City of Albuquerque Stormwater Construction Site Inspection Report

ESC File No.	K09E043	Project Name:	L&C Transport Office & Shop		
NPDES Id. No.	NMR10032W	Location:	112 94th Street NW		
5/13/2021	Owner			Contractor	
Operator	F&J Homebuilders				
Contact name & title	Freddie Lopez		Lorena		
e-mail	fjhomebuilders@yahoo.com		lorenaj89@gmail.com		
Contact Phone #	505-362-1790				
COA Inspector	Thomas Evans		Start/End Time:	3:00 PM/3:05 PM	
Construction Phase:	Building Construction/earthwork				
Type of Inspection:	Regular	Storm Event	Past Storm Event >0.25"	311/Complaint	Follow Up
Weather at time of inspection?	clear		Temperature:	~ 80	
Estimated date of last storm 0.25" or greater	5/3/2021

## EROSION & SEDIMENT CONTROL PLAN & DETAILS

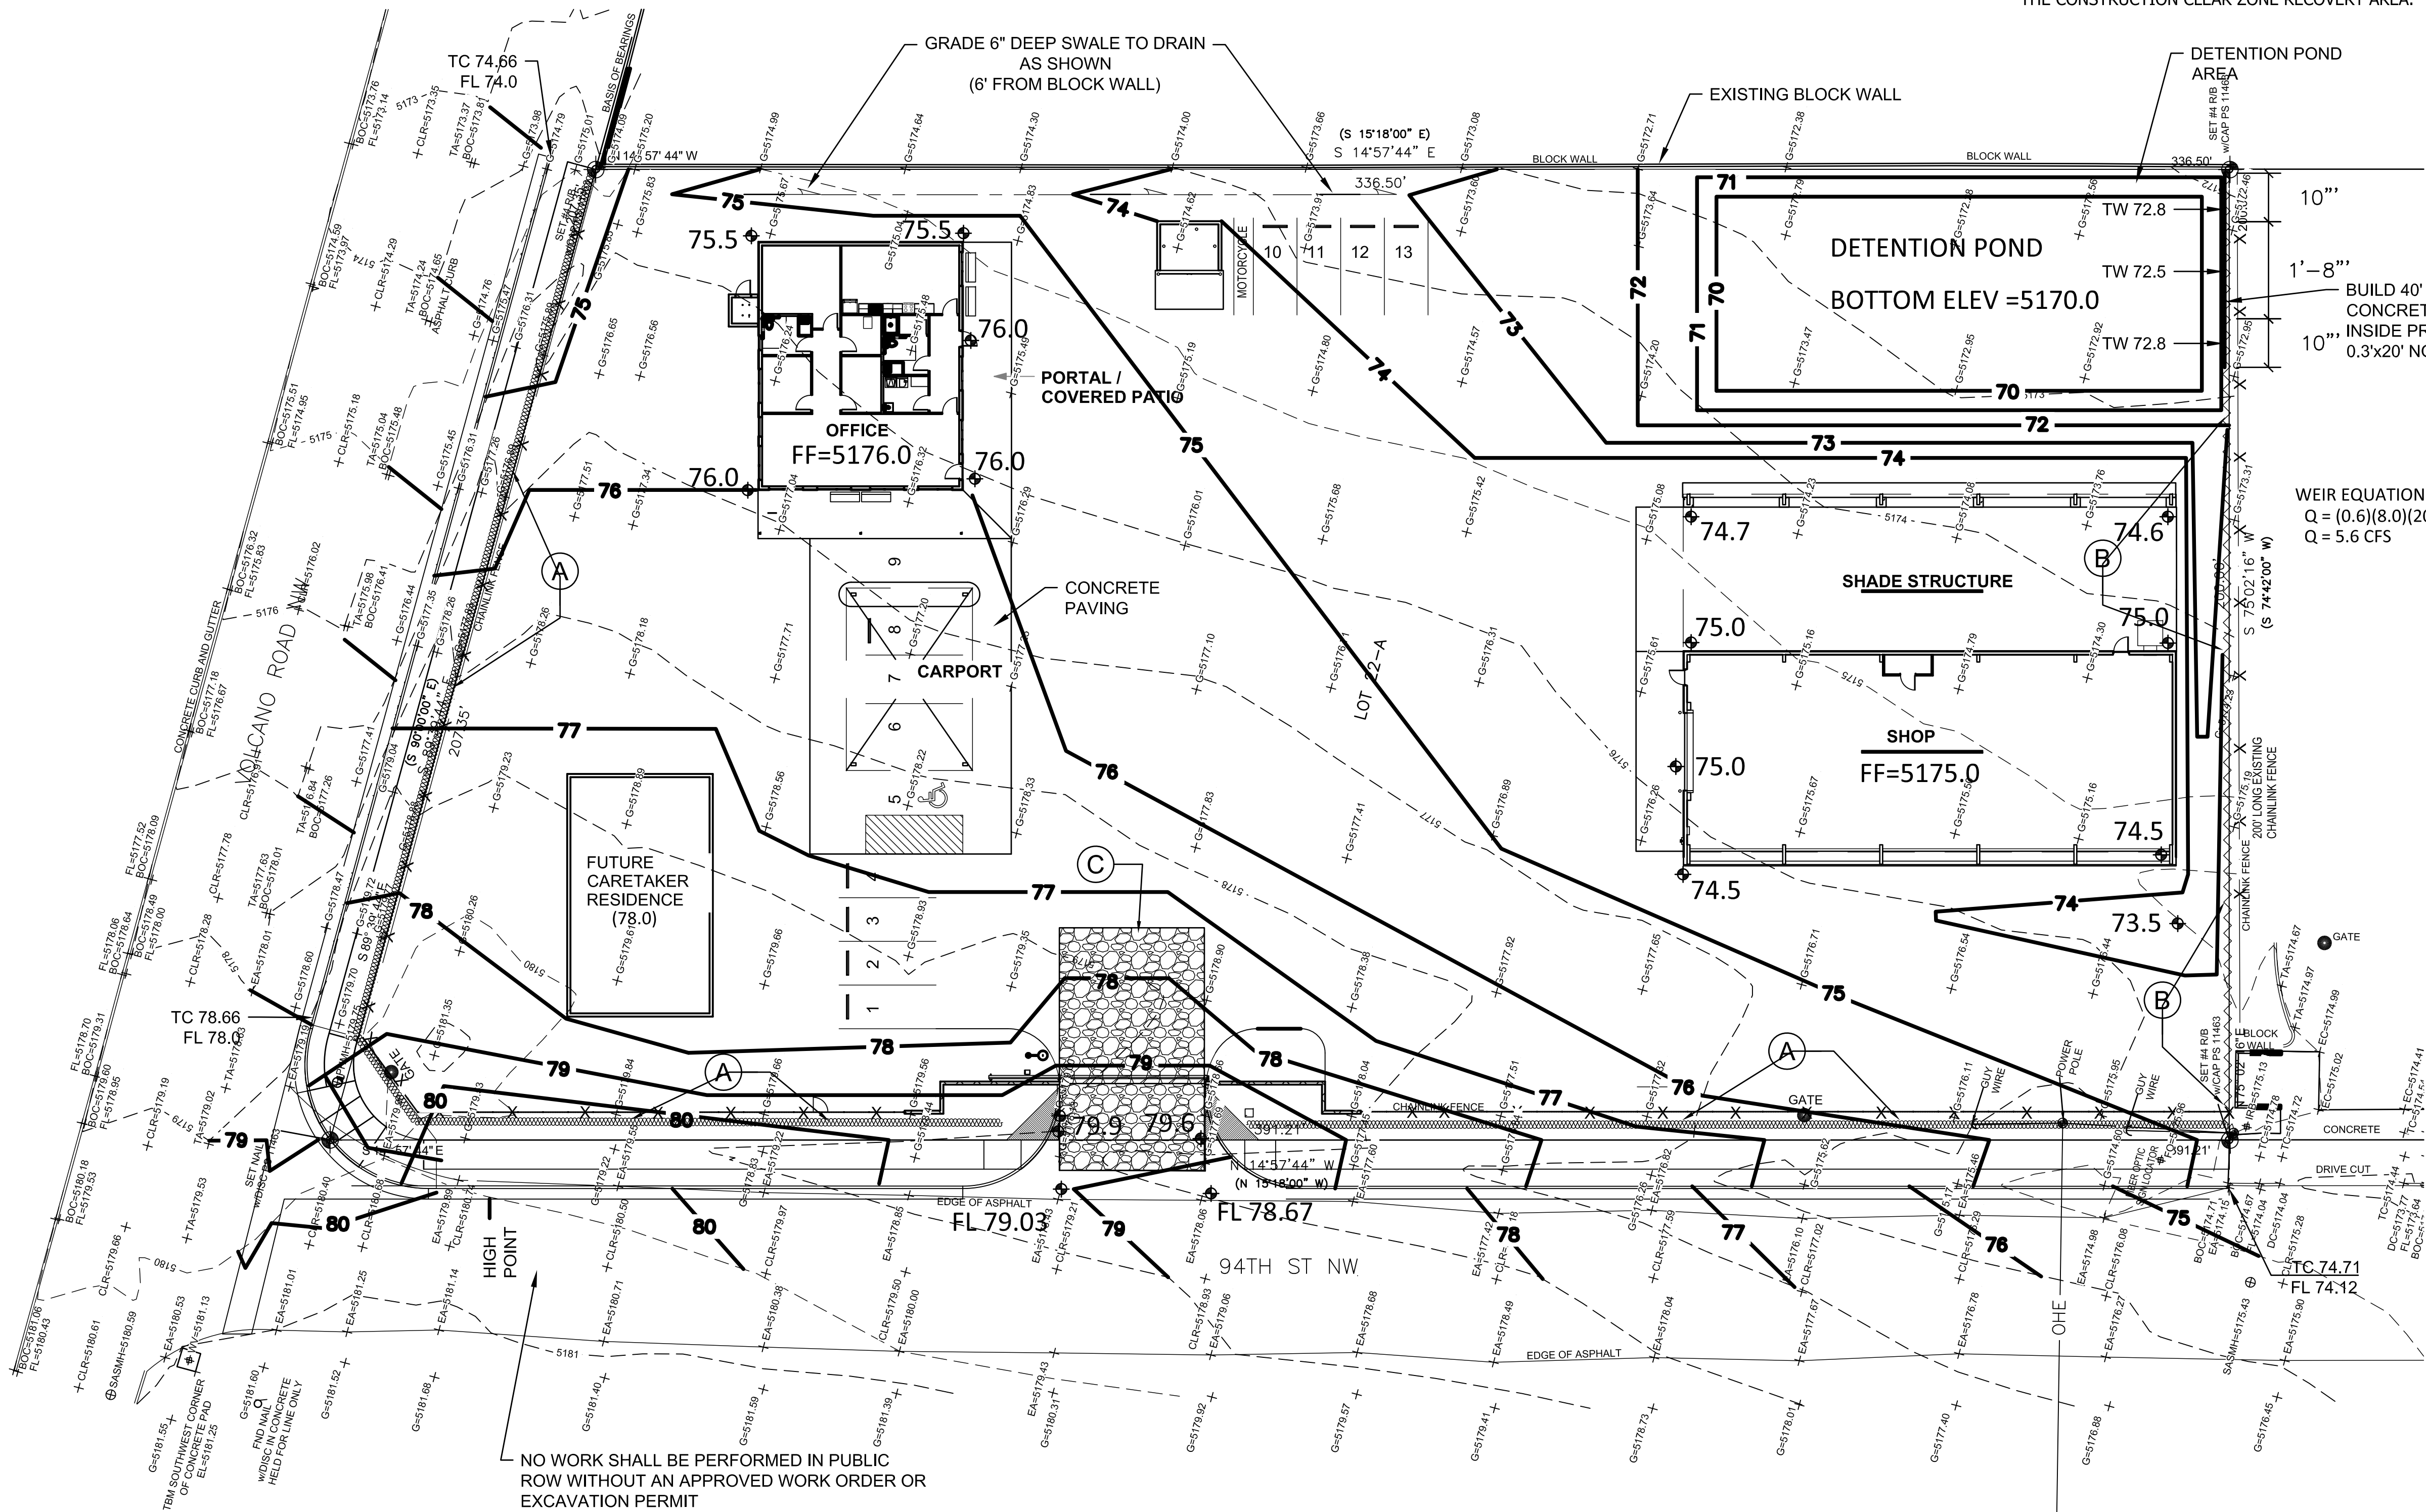
Item Number	Deficiency/ Corrective Action				
1	No BMPs on North and West fence lines. Install sediment control BMPs to prevent sediment from exiting the site.				
2	Washout on the ground. Direct wash water from concrete, paint, and stucco into a leak-proof container per CGP 2.3.4. Removed and dispose hardened washout with other waste per CGP 2.3.3
